**SSD 16\_7974: SUSAN WAKIL AO HEALTH BUILDING PRECINCT STAGE 1  
UNIVERSITY OF SYDNEY, CAMPERDOWN CAMPUS**

**UNIVERSITY OF SYDNEY RESPONSE TO SUBMISSIONS**

**12 FEBRUARY 2018**

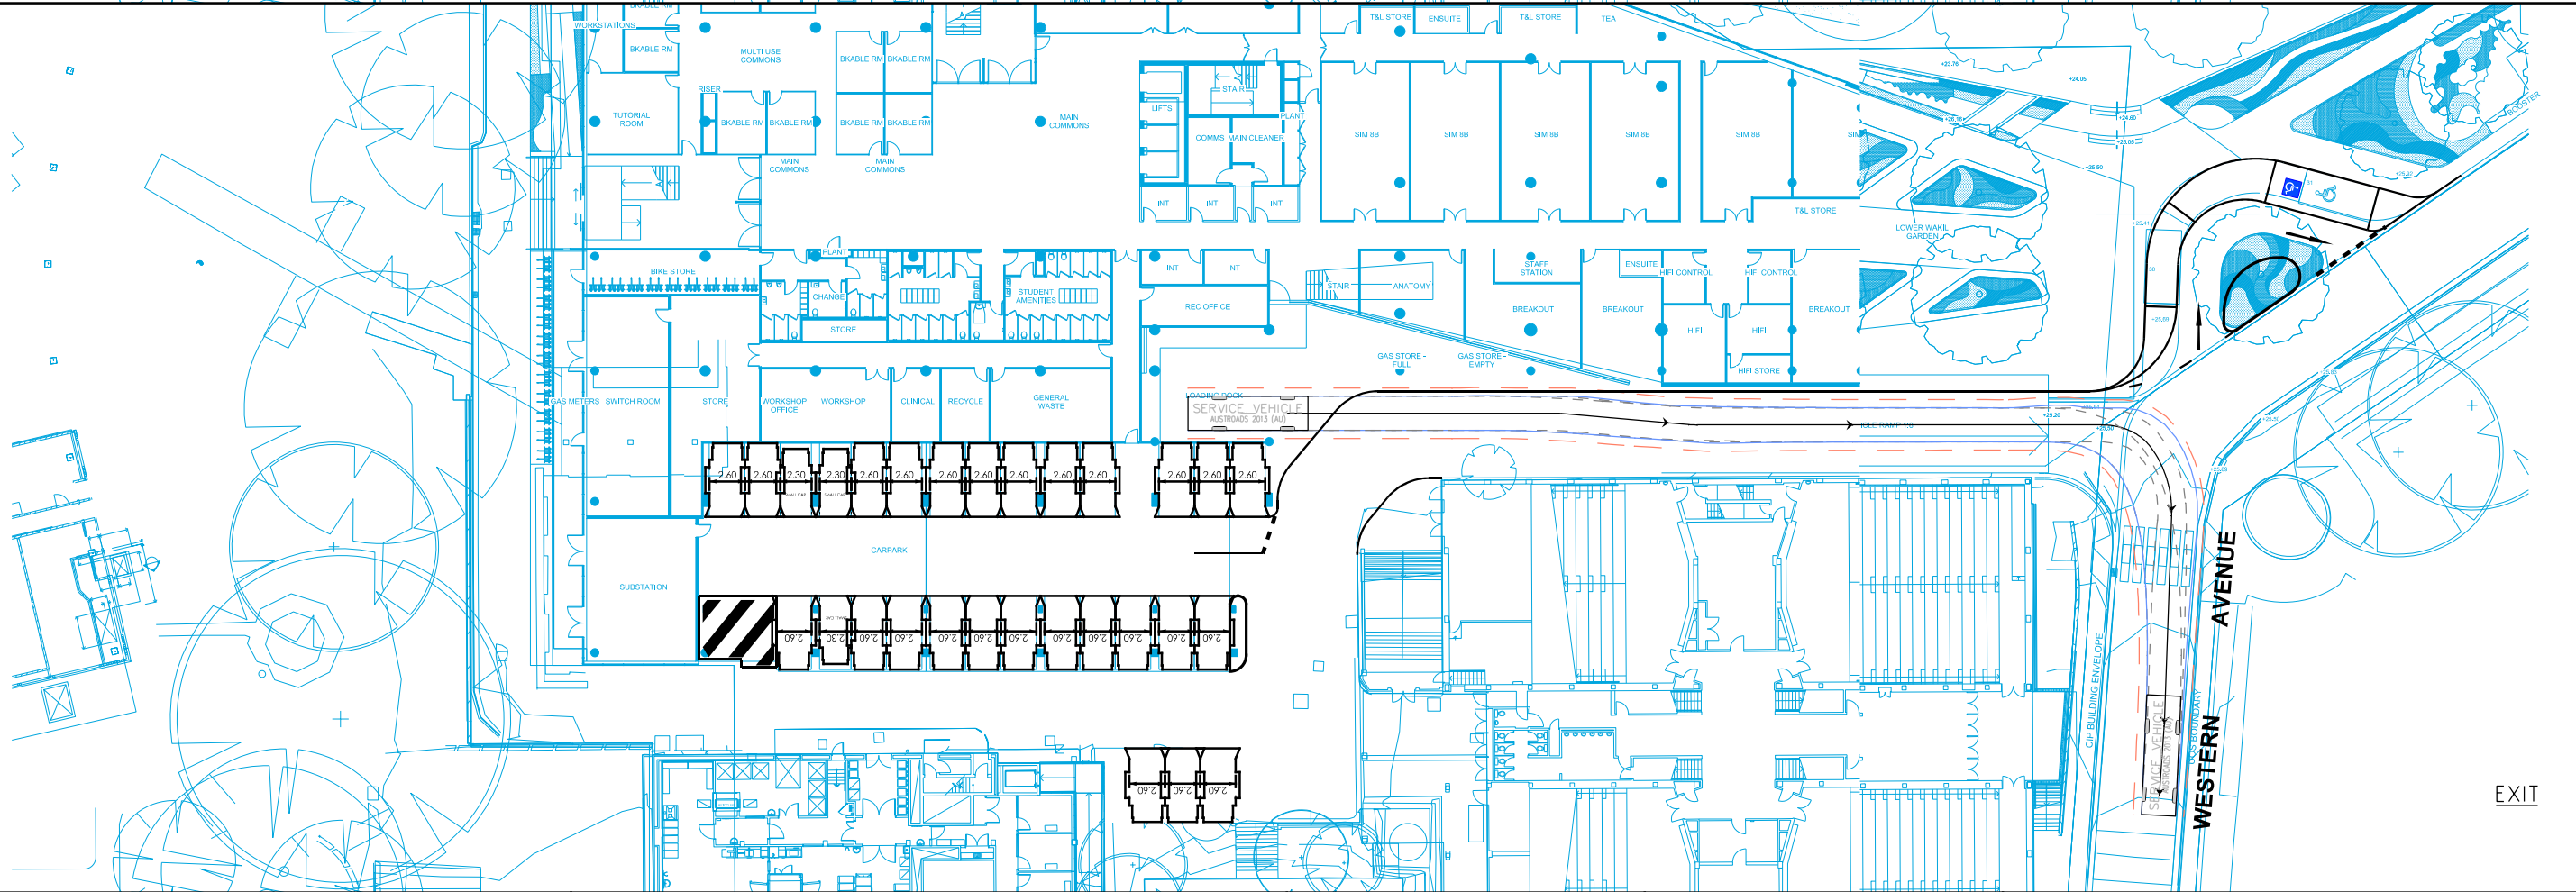
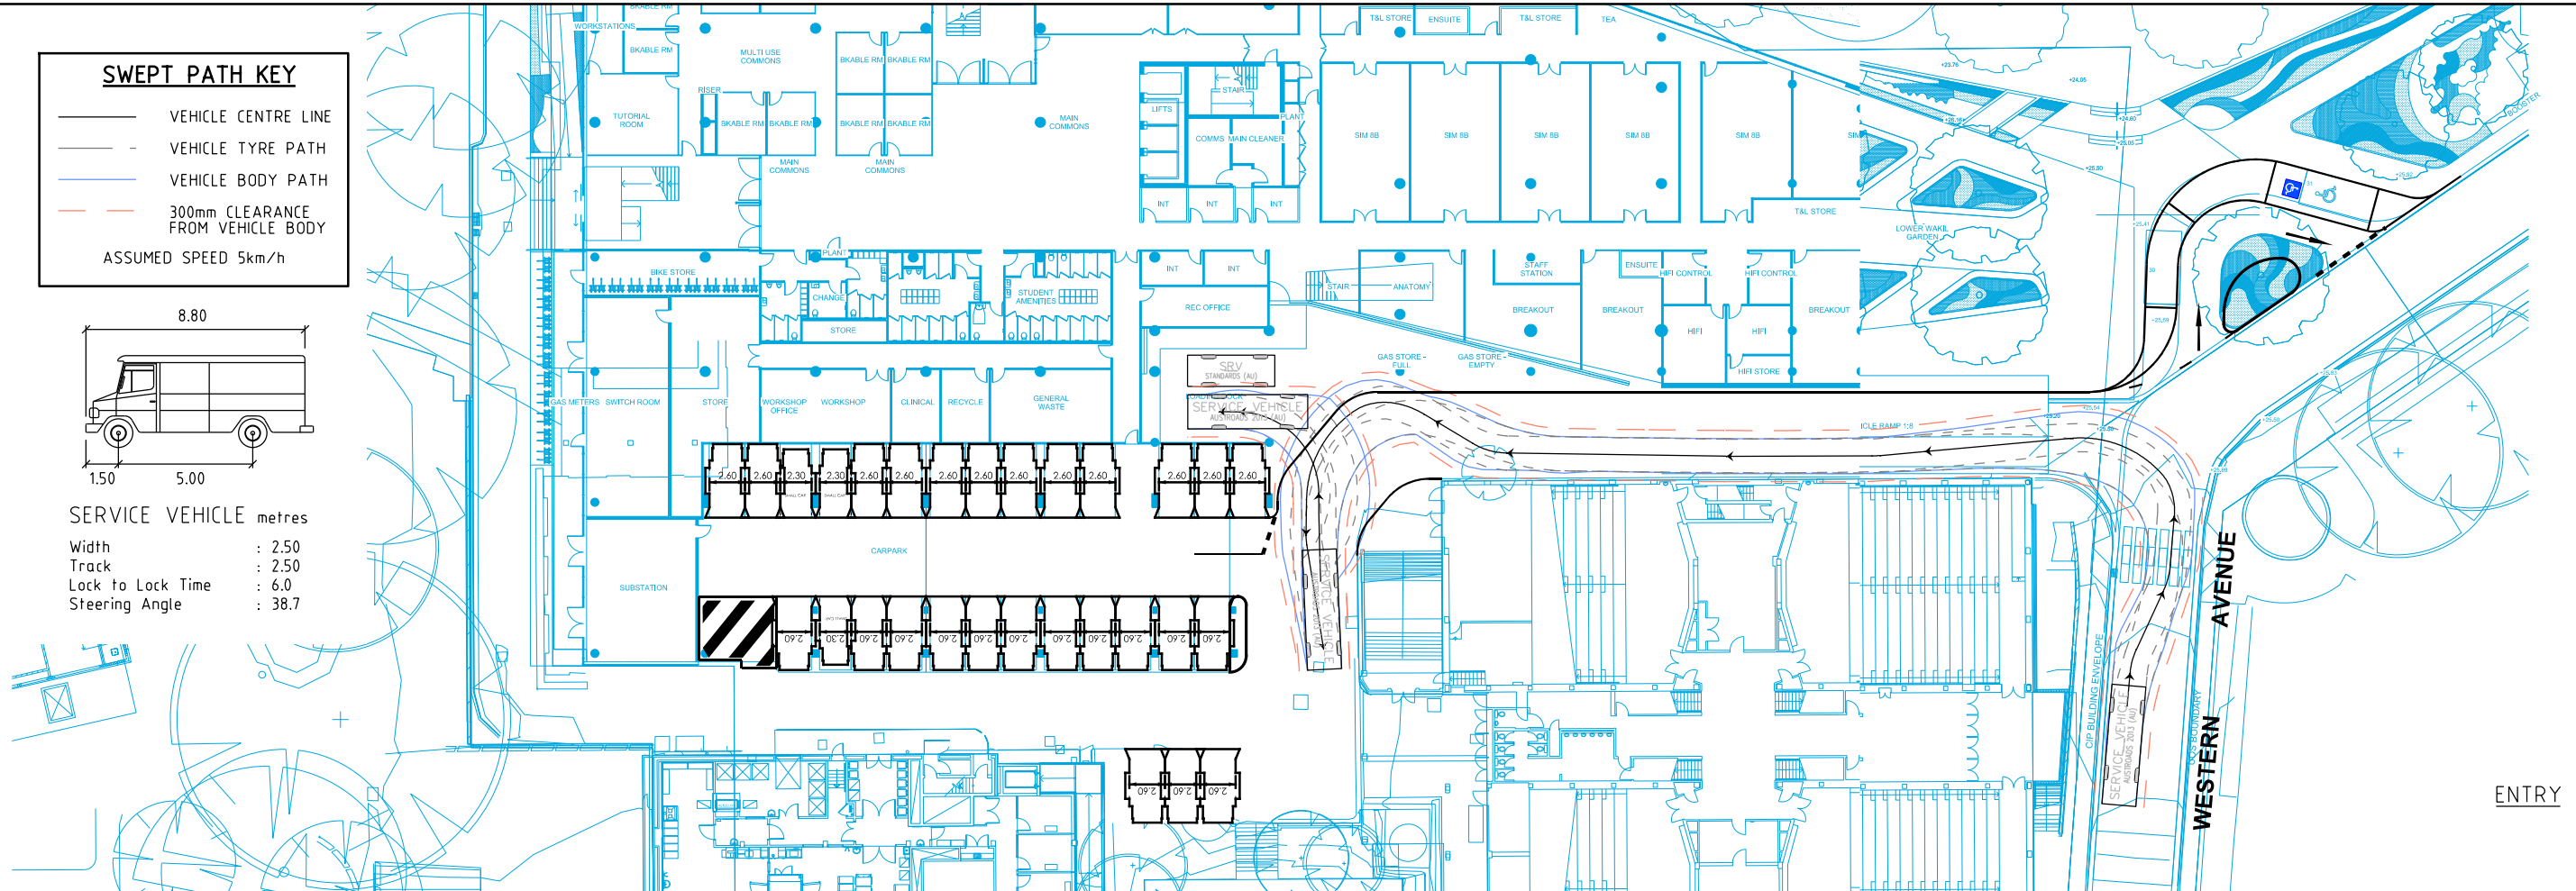
SSD 16_7974 – SUSAN WAKIL HEALTH PRECINCT – BUILDING STAGE 1	
TfNSW ISSUE	UNIVERSITY OF SYDNEY PROJECT RESPONSE
<p><b>Swept Path Analysis</b></p> <ul style="list-style-type: none"> <li>The proposed access arrangement requires service vehicles to straddle along Western Avenue to make the turns (ingress/egress) to the site and the loading dock. This proposed access arrangement would not be able to accommodate simultaneous vehicle movements into the site for general traffic and service vehicles, which carries a safety risk for pedestrians as the location of the straddling would occur near a pedestrian crossing; and</li> <li>Sheet 6 of 7 of the swept path drawing shows swept paths for 8.8m and 12.5m vehicles using the area near the proposed drop off zone to turn around. The purpose of these vehicles is not clear, including how these movements would be achieved within the proposed kerb alignment.</li> </ul> <p><u>Recommendation:</u> A Road Safety Audit (RSA) should be undertaken by a TfNSW accredited road safety auditor. The design drawings should be reviewed based on the results of the RSA.</p>	<p>A 12.5m heavy rigid vehicle is currently required to cross the centreline of Western Avenue in order to gain access to the site access this driveway for the existing use. Therefore, this is currently an existing condition in order to allow vehicles of this size to gain access to the site. This is replicated for the proposed development. Refer to sheet 2 and 3 of Appendix K. This would become less of an issue in the future stages if Western Ave north were to be terminated.</p> <p>Sheet 6 demonstrates the requirement for a fire vehicle to turnaround following the closure of Western Ave north. The proposed drop-off area is proposed to be constructed in a way that allows the service vehicle movement to be possible (i.e. no physical obstructions to prevent this from occurring). The fire brigade has two vehicles (12.5m heavy rigid vehicle and an 8.8m medium rigid vehicle). Both swept paths have been provided for information, and show that the medium rigid vehicle is acceptable in this location.</p> <p>The University requests the completion of a RSA as a SSD Condition of Consent.</p>

Figure 1 – Northern Elevation Signage

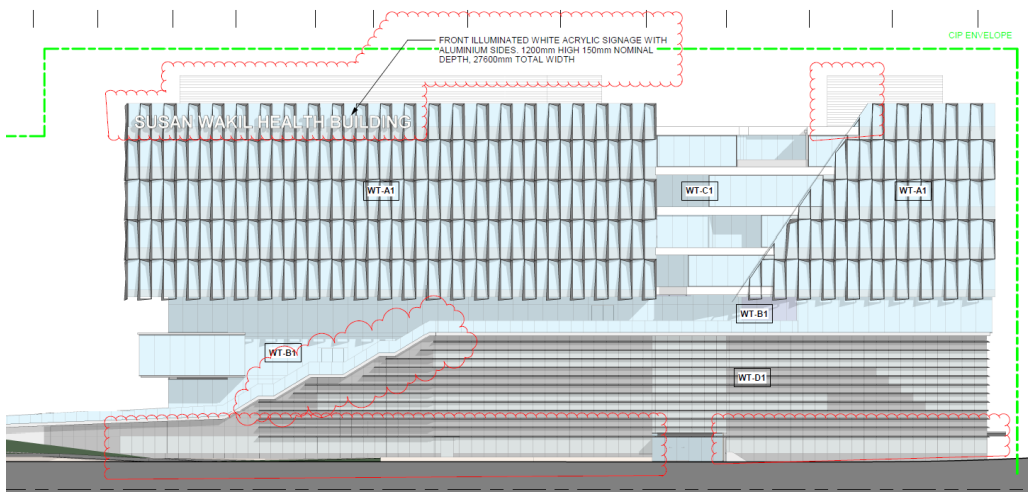
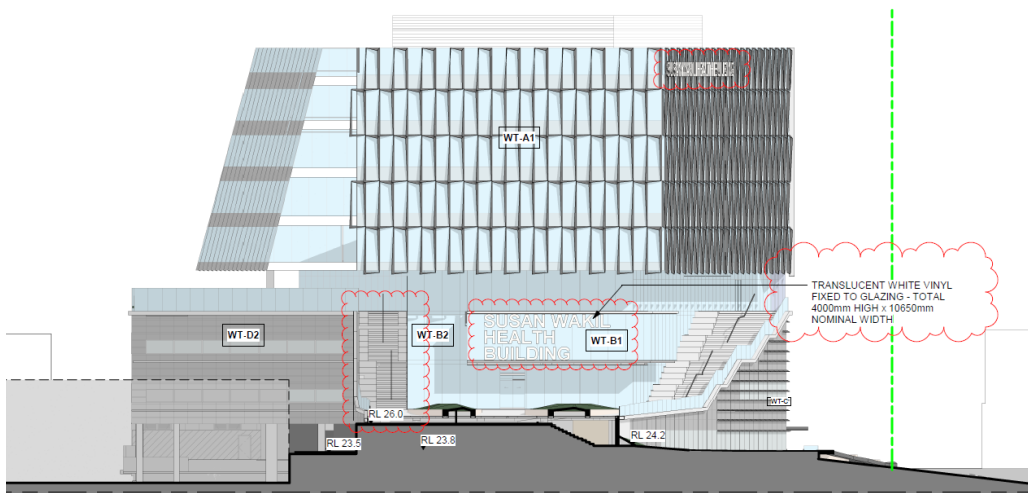
<b>9. Information Not provided</b> <ul style="list-style-type: none"> <li>Details on building signage</li> <li>Details on public art incorporation into the building and surrounding public domain</li> </ul>	<p>Refer to updated Architectural elevations included in Appendix A</p> <p>Urbis have prepared a SEPP 64 assessment for signage, which is included at Appendix G.</p>
